Arun District Council
Arun Civic Centre
Maltravers Road
Littlehampton
West Sussex BN17 5LF
Planning & Building Control General Enquiries
Tel: (01903) 737756 Fax: (01903) 730442
Dx: 57406 Littlehampton
Minicom: 01903 732765
e-mail: planning@arun.gov.uk
website: www.arun.gov.uk/planning

Application No: EP/142/21/HH
Site Address: 38 Vermont Drive East Preston BN16 1LG
Description of works: Conversion of roofspace to habitable use to include 2 x side dormers, Juliet balcony and conversion of roof from hip to gable end and single storey ground infill extension.

Thank you for your internet representation made on 1st December 2021 which has been recorded as an objection with the comments as follows:

PROPOSED SOUTH ELEVATION 1:100

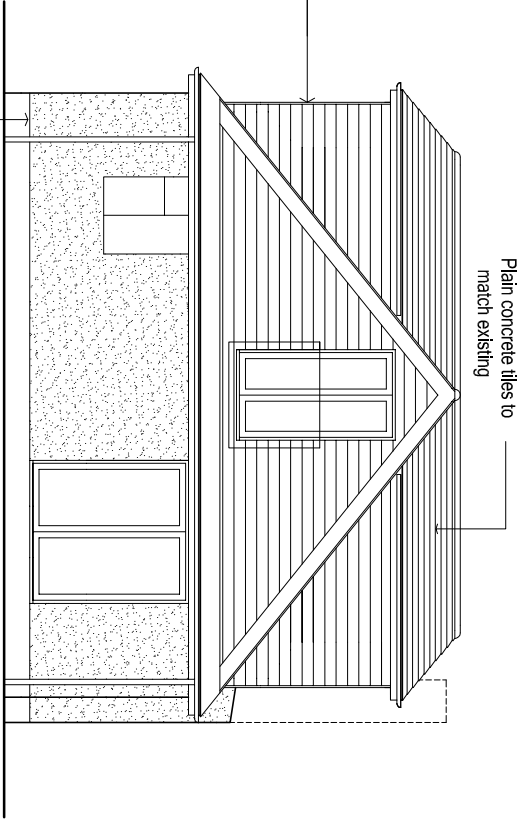
SOUTH ELEVATION

The Juliet Balcony is totally inappropriate as it will be overlooking adjacent properties and be overbearing and intrusive to neighbours as the gardens in both Vermont Drive and The Nookery are small. Therefore this will affect the amenities of the occupants of nearby properties in breach of policies D DM1 of the Arun Local Plan. The window should if permitted should be of occluded glass and non opening below 1.5 metres as above.

ARW Design	DRAWING TITLE: PROPOSED ELEVATIONS PROJECT: PROPOSED LOFT CONVERSION WITH HIP TO GABLE END & DORMERS TO SIDE ELEVATIONS		LOCATION: 38, VERMONT DRIVE, EAST PRESTON CLIENT: C. NORTH		SCALE: AS NOTED @ paper size A3 DATE: OCT 2021		DRAWING NO: 6037/2
					DRAWN: ARW		
					REVISION:

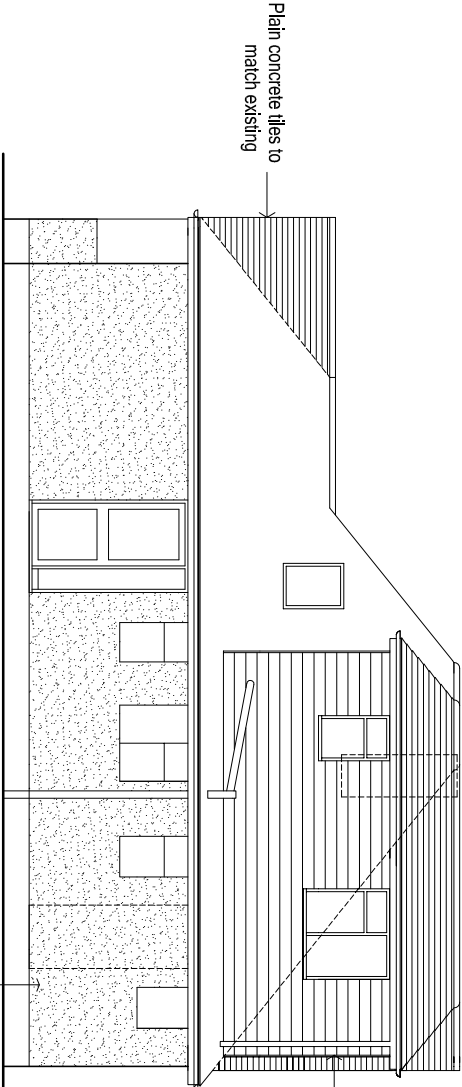
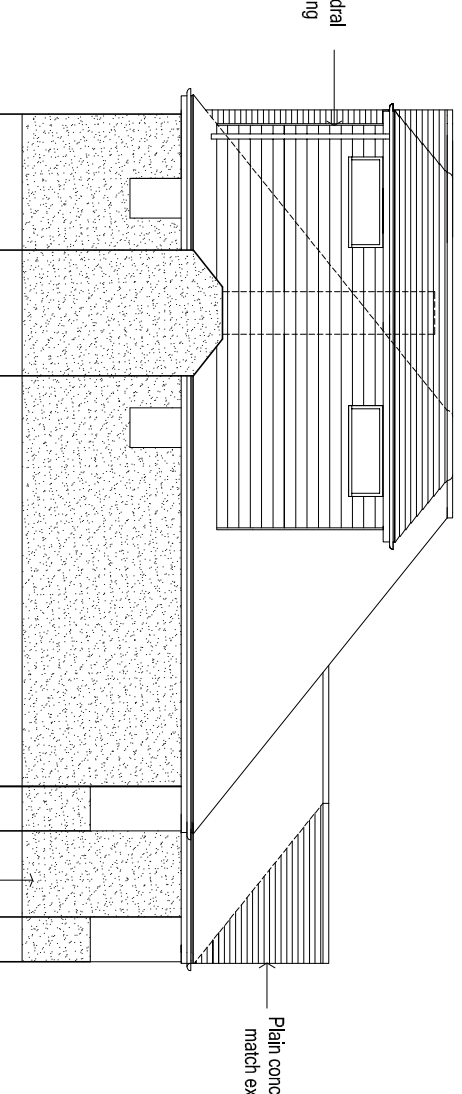
I wish to object to this application. My grounds are.
EAST AND WEST ELEVATIONS

The hip to gable extensions on both the east and west elevations are out of proportion and would affect all the neighbouring properties. and would appear to contravene Policy 3 of the East Preston Neighbourhood plan in that they will alter the form of the roof of 38 Vermont Drive. It is unclear what type of glass would be used in the windows or how they would open. I would say that if permission is granted they would need to be of occluded glass and non opening below 1.5 meters as per the permission for 32 Vermont Drive ref EP/57/20/HH.
